Online Comment

Application H23-1093-20
Location Adj. Corner House Churchgate Whaplode PE12 6TA
Proposal Details of brick, site & floor levels, boundary treatment, scheme to deal with contamination and soakaway system for disposal of surface water (Conditions 3, 5, 6, 7 & 9 of H23-0714-20)

Name Sue Armour
Address Environmental Protection Officer SHDC PE11 2XE

**Typical Edge Detail - Suspended Slab,
Option 1.**

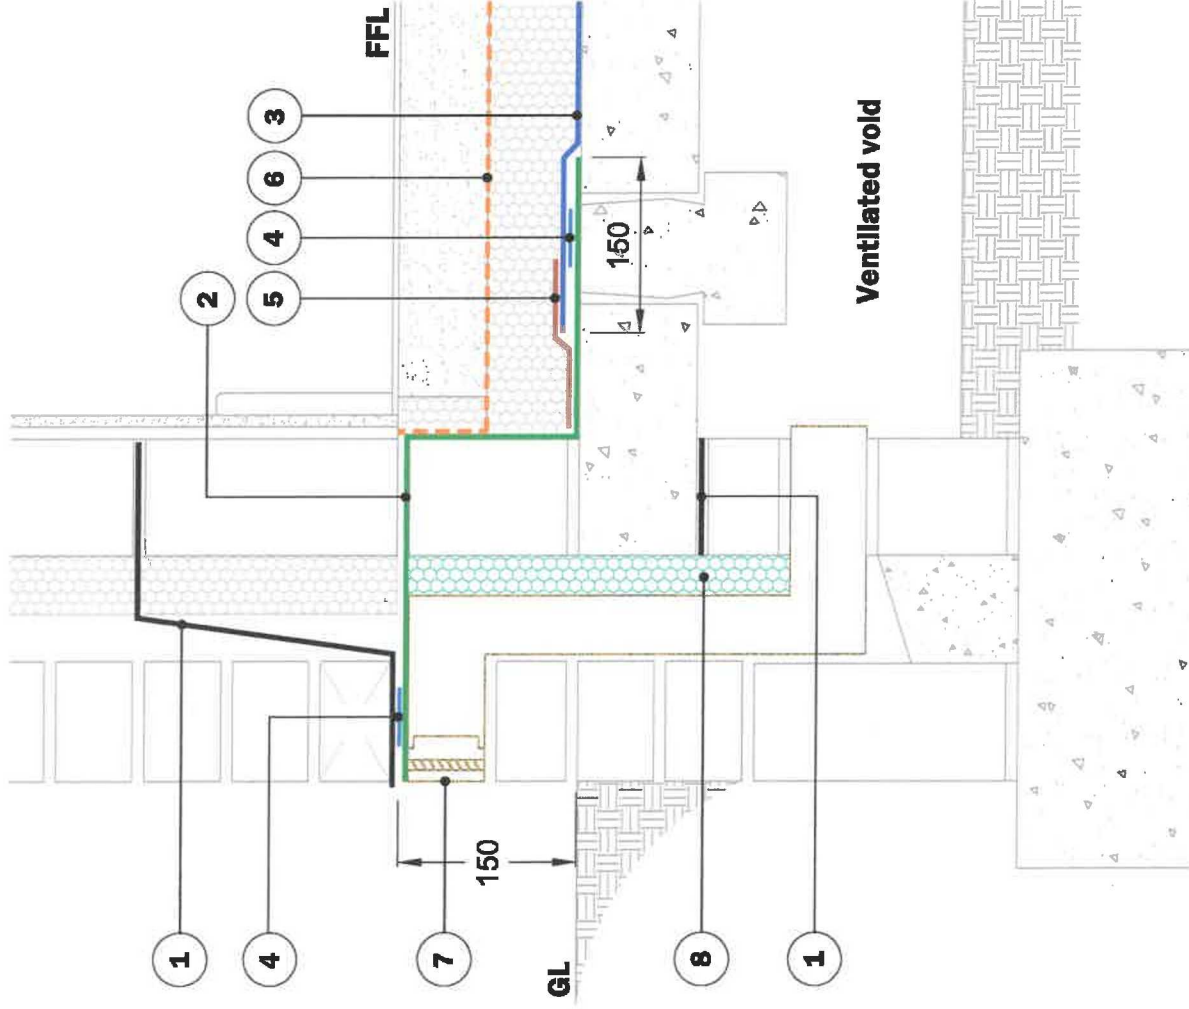
The report recommends either CS2 or NHBC amber 1 gas protection measures. Either are acceptable. G R Merchant Ltd have sent through the attached drawings and a gas data sheet, and whilst the gas membrane proposed is suitable, it is not integrated into the drawings, nor is there any subfloor venting detailed. Without further details I cannot recommend discharge of condition 7 part iii.
